Householder Proforma

Application Ref: 2021/0742
Address: 18 Bank End Avenue, Worsborough Dale, Barnsley, S70 4QR
Neighbour Representations: No
Consultations None
Property Description: the semi detached red brick built dwelling is located in a purely residential area of similar styled properties.
The property is located is a triangular shaped plot which narrows to the rear and currently benefits from a pre-fabricated detached garage located forward of the principle elevation.

Proposed Extension: erection of a two storey side extension
UDP Designation: Housing Policy Area
Local Plan Designation: Urban Fabric
Conservation Area: No
Relevant History: N/A
Acceptable in Principle: Yes

SECTION A-A

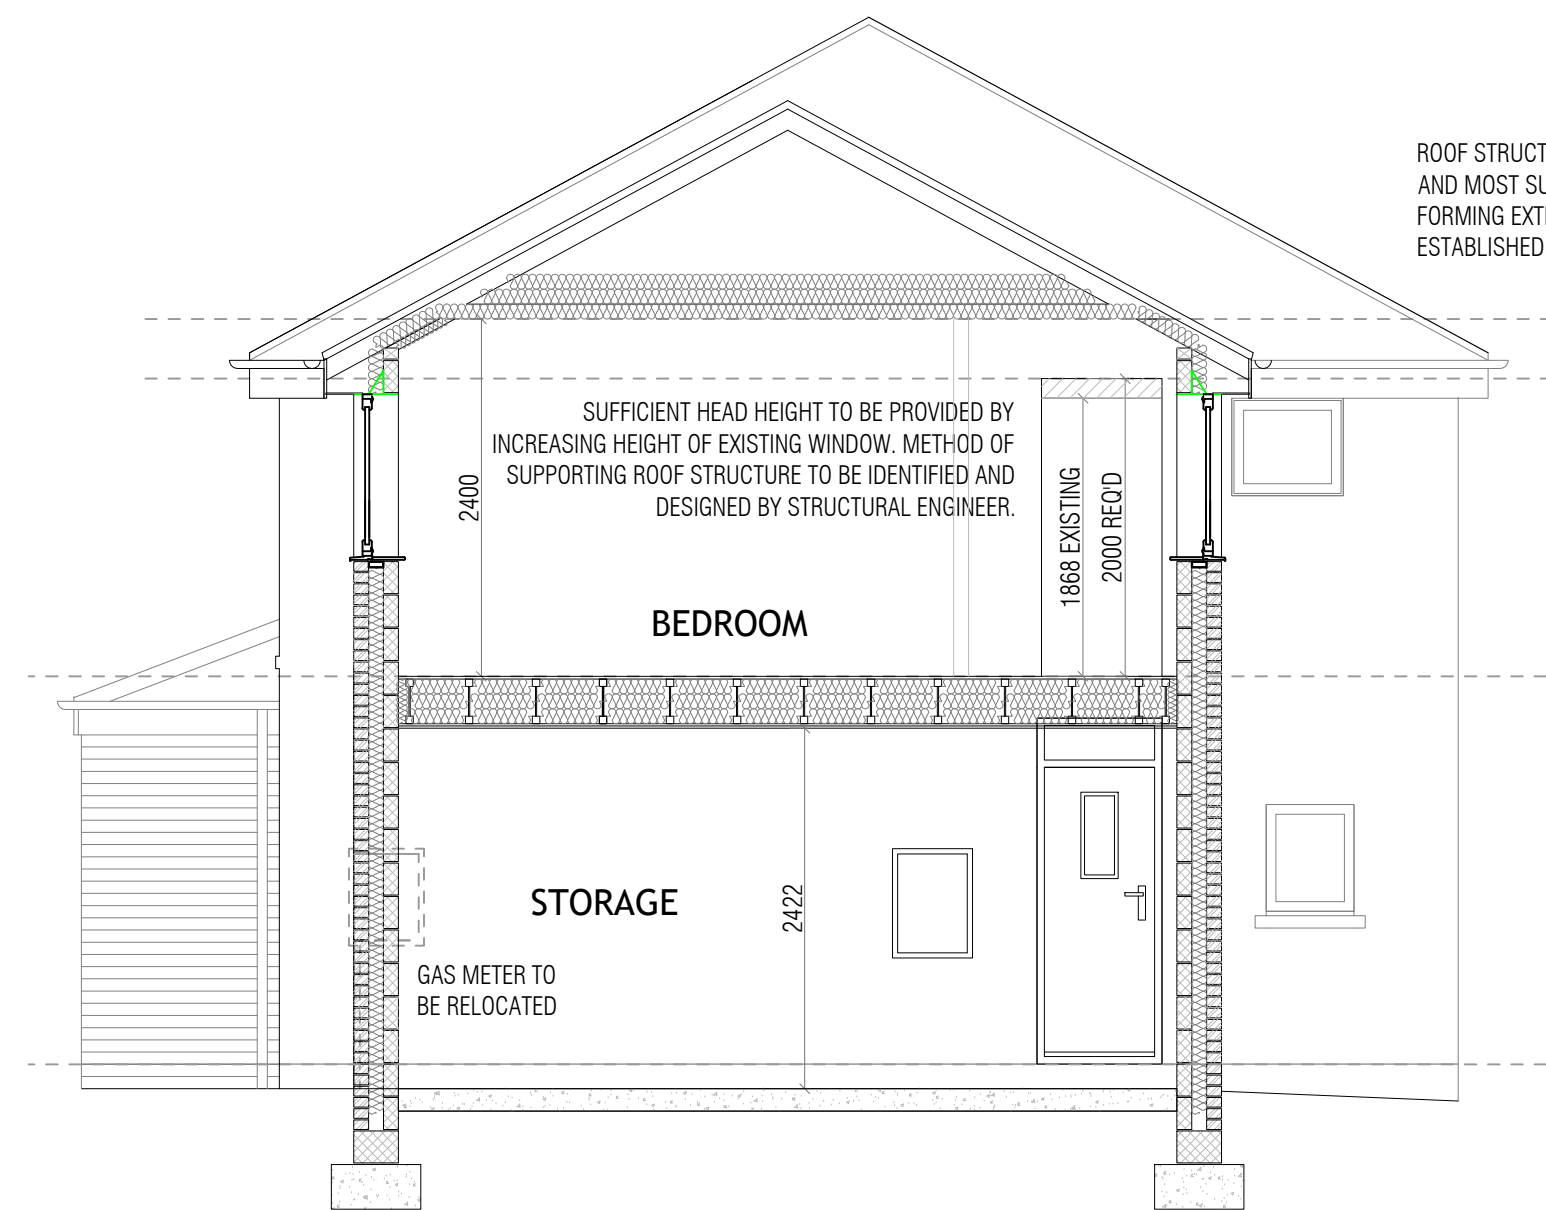
Yes / No (include comment if required)
Single Storey	
1. set back	
Two Storey / First Floor	
2. set back / set down (500mm minimum)	Yes: 500mm
3. less than 2/3 the width of the original dwelling	Property width - 5.6m Extension width allowed - 3.7m Extension width proposed - 3.7m at front reducing to 1.9m at rear
All

4. roof design corresponds to existing	Yes; hipped roof extension on hipped roof property
5. windows / doors of a similar design / proportion	Yes
6. habitable room windows on the side elevation	No

7. materials to match	yes
8. neighbouring property extended to side or windows?	No extension at neighbouring property but there is a window on the side elevation, however this window is serving a landing and therefore is not classed as a habitable room window.

9. Any change to parking or access?	No; dwelling changing from 3bed to 4bed no additional provision required, improving situation with a driveway 5.5m in length following the removal of a pre-fabricated garage which is located forward of the principle
